Inner West Council Response: SSD-78268465 – Newington College Redevelopment (Concept and Stage 1)

Property: 200-244 Stanmore Road and 221-235 Stanmore Road, Stanmore

Attachment A - Consolidated Inner West Council Officer comments SSD-78268465 – Newington College Redevelopment (Concept and Stage 1)

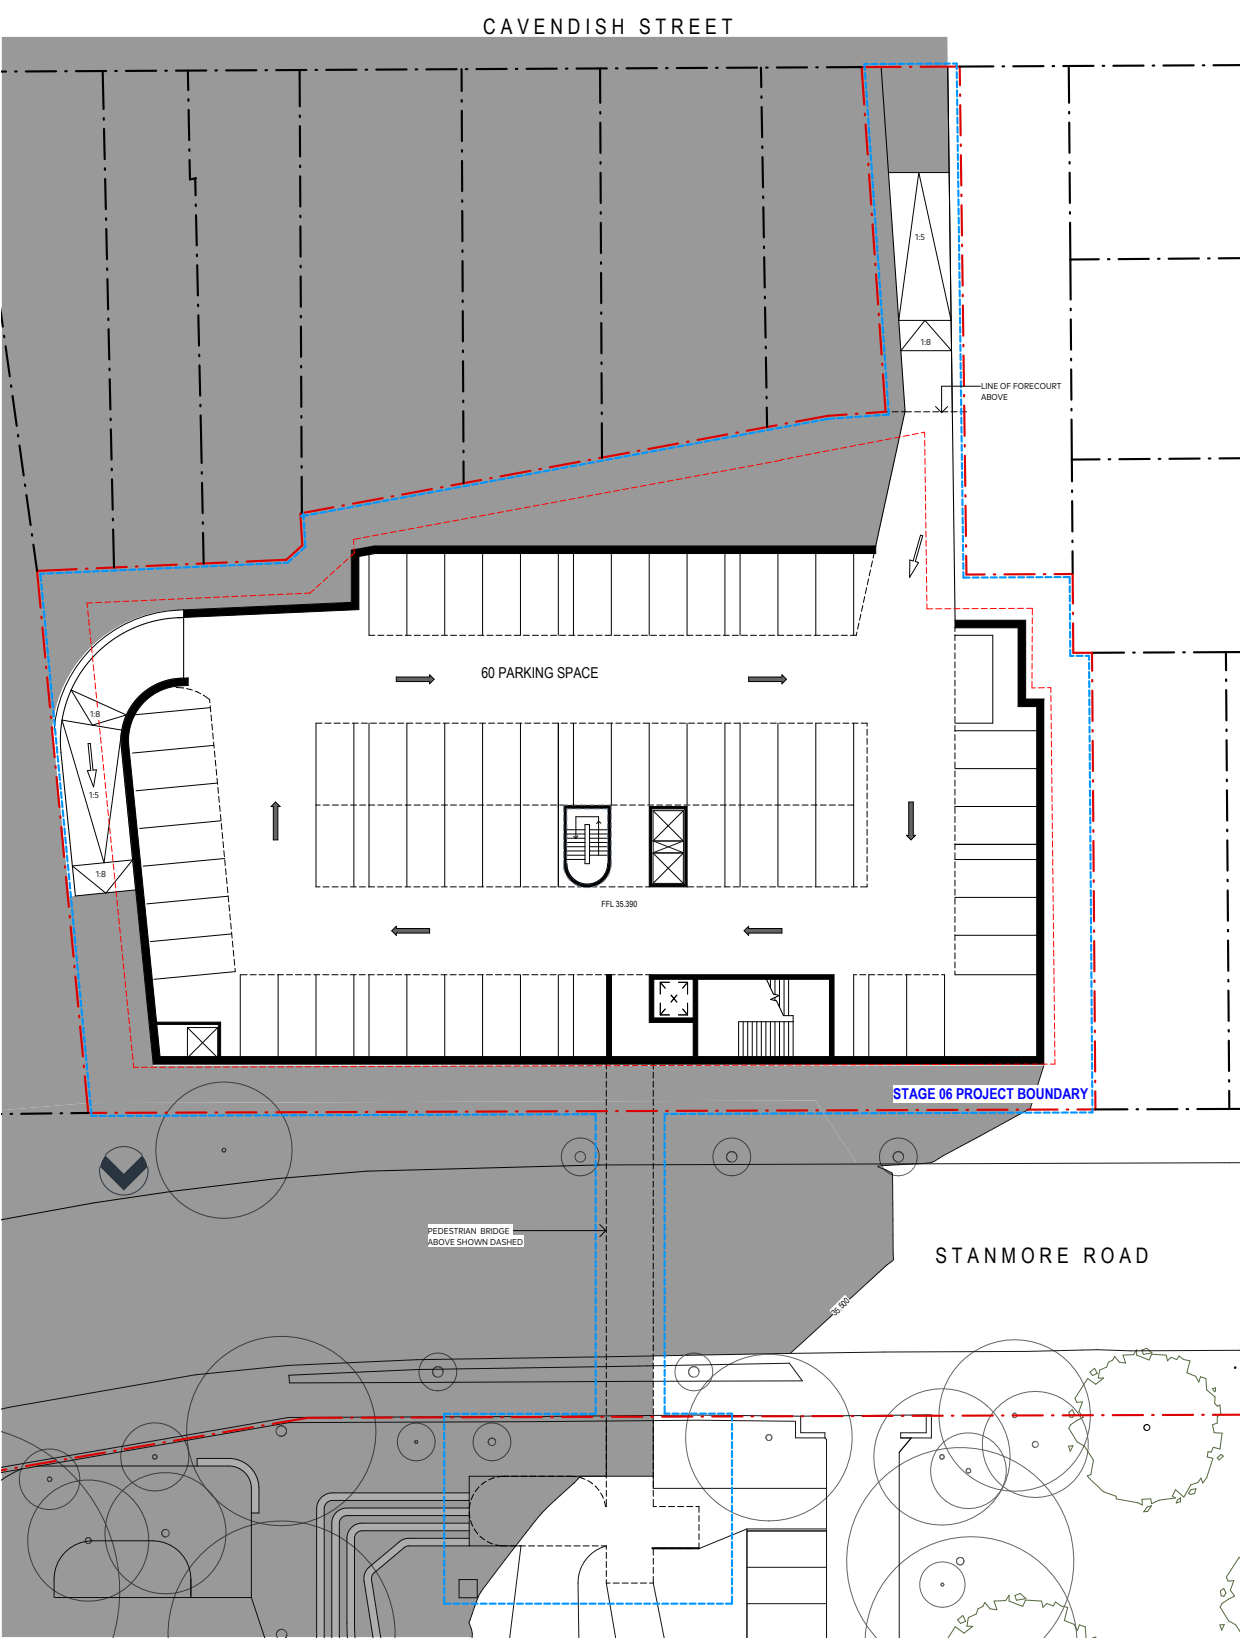
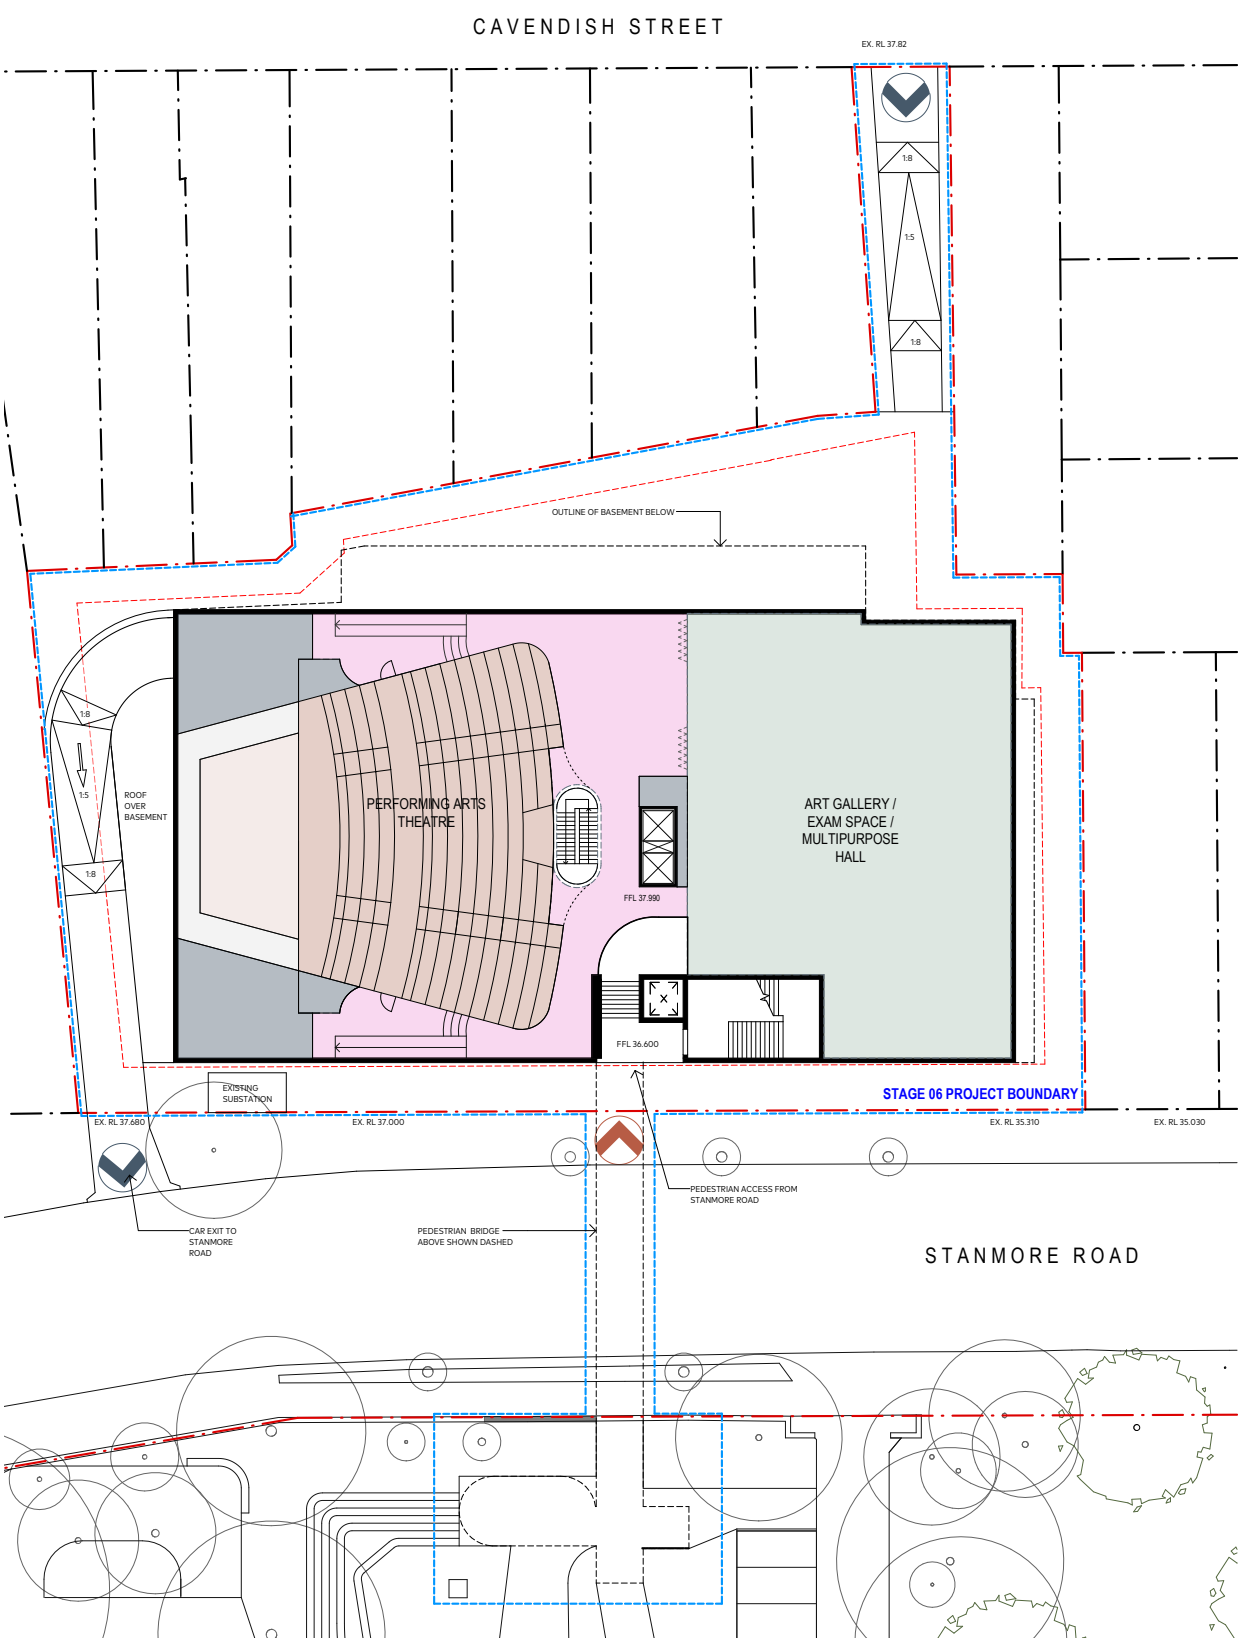
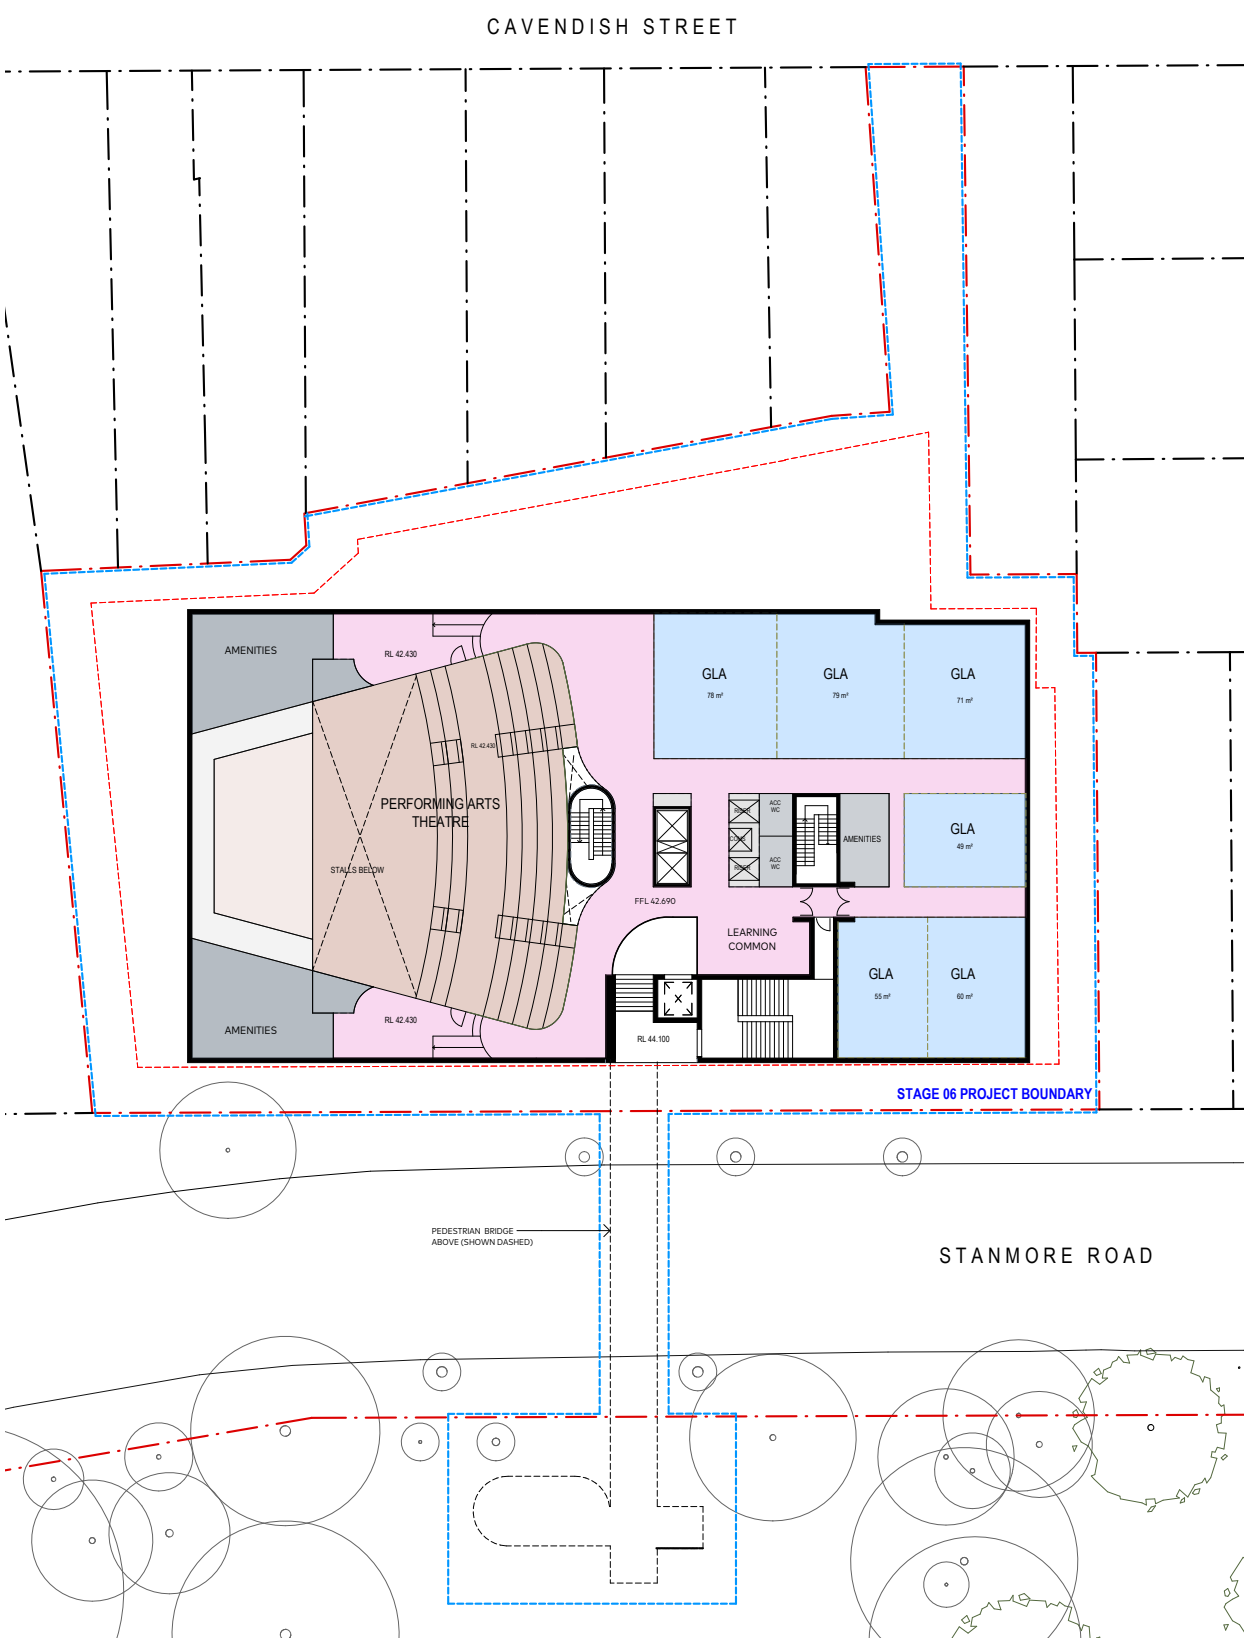
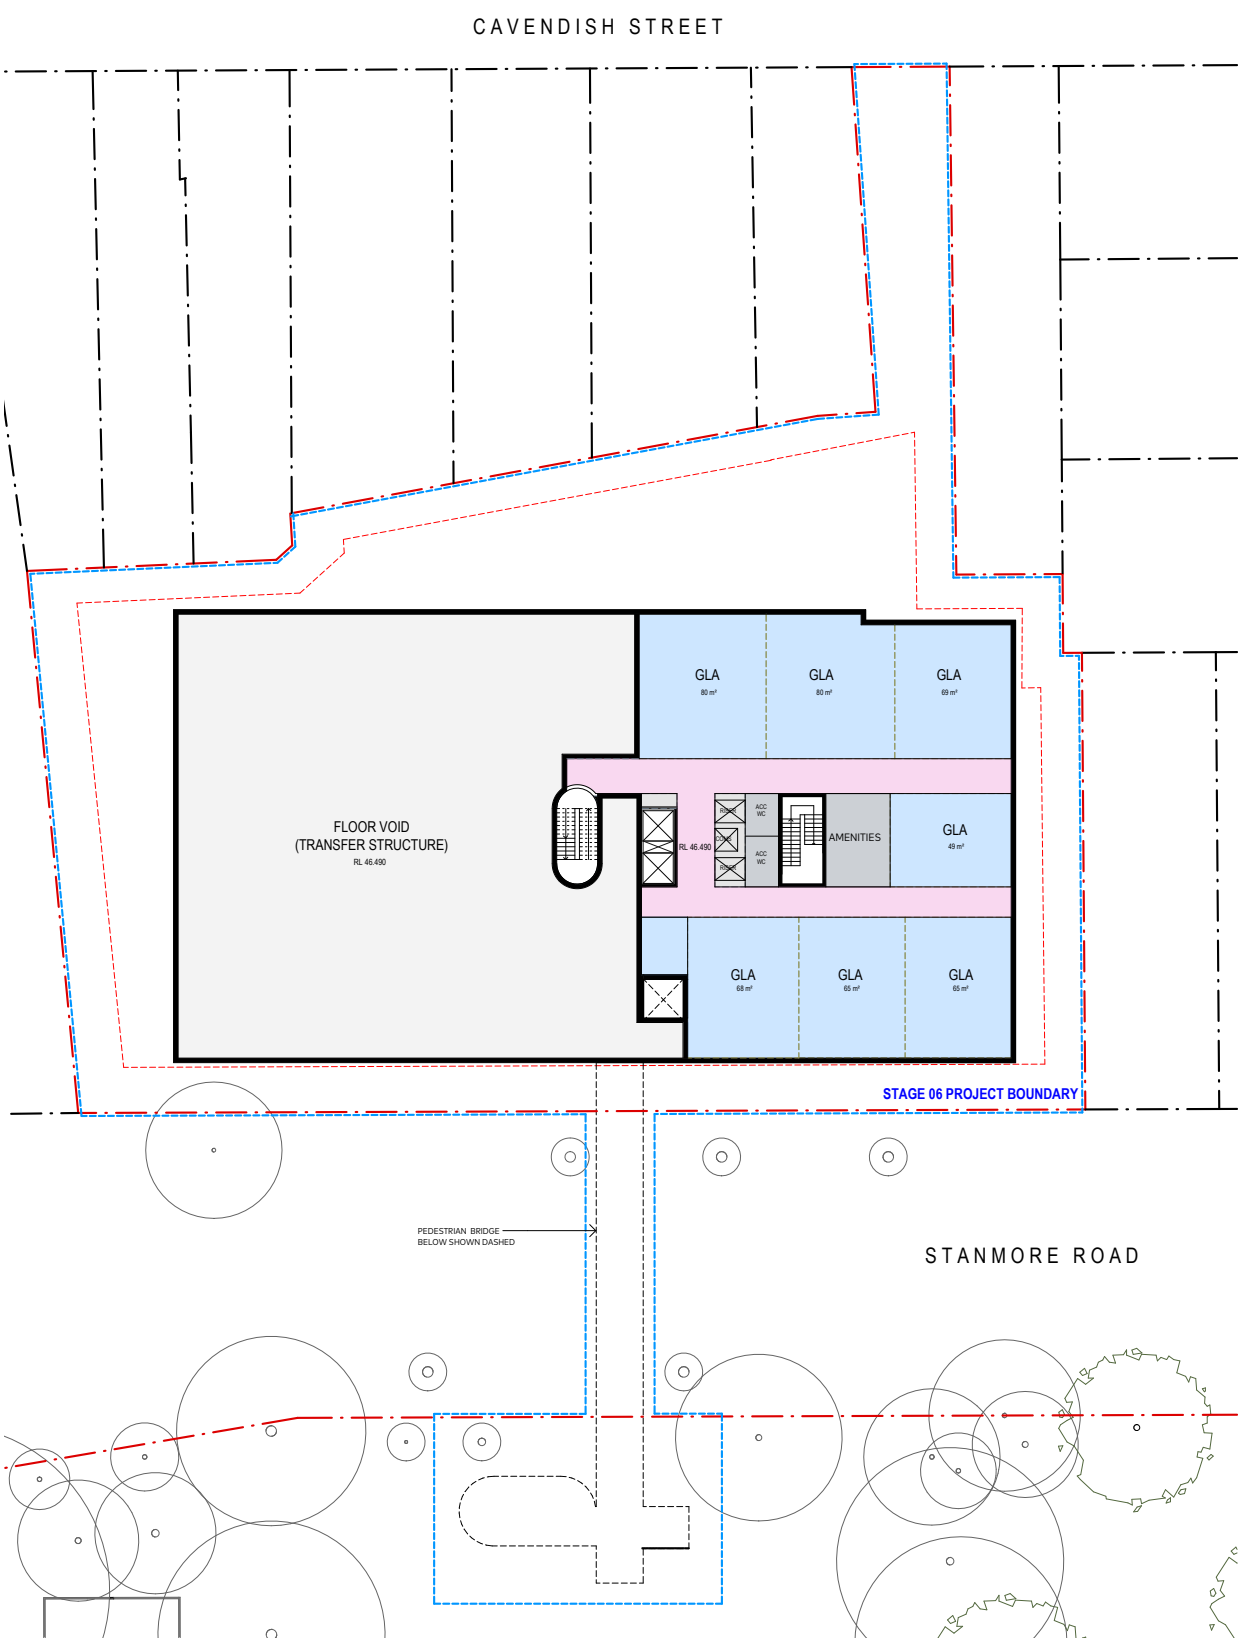
Further detail and refinement are required to demonstrate that the proposed building envelope and massing of the Concordia building presents as an appropriate design response to the site and its context, including the following:

- f) Further refinement of the proposed scale and massing, having regard to the prevailing two storey character of development along the street and amenity impacts. Particular consideration should also be given to the building edges and interfaces with neighbouring residential land to ensure an appropriate built form transition.
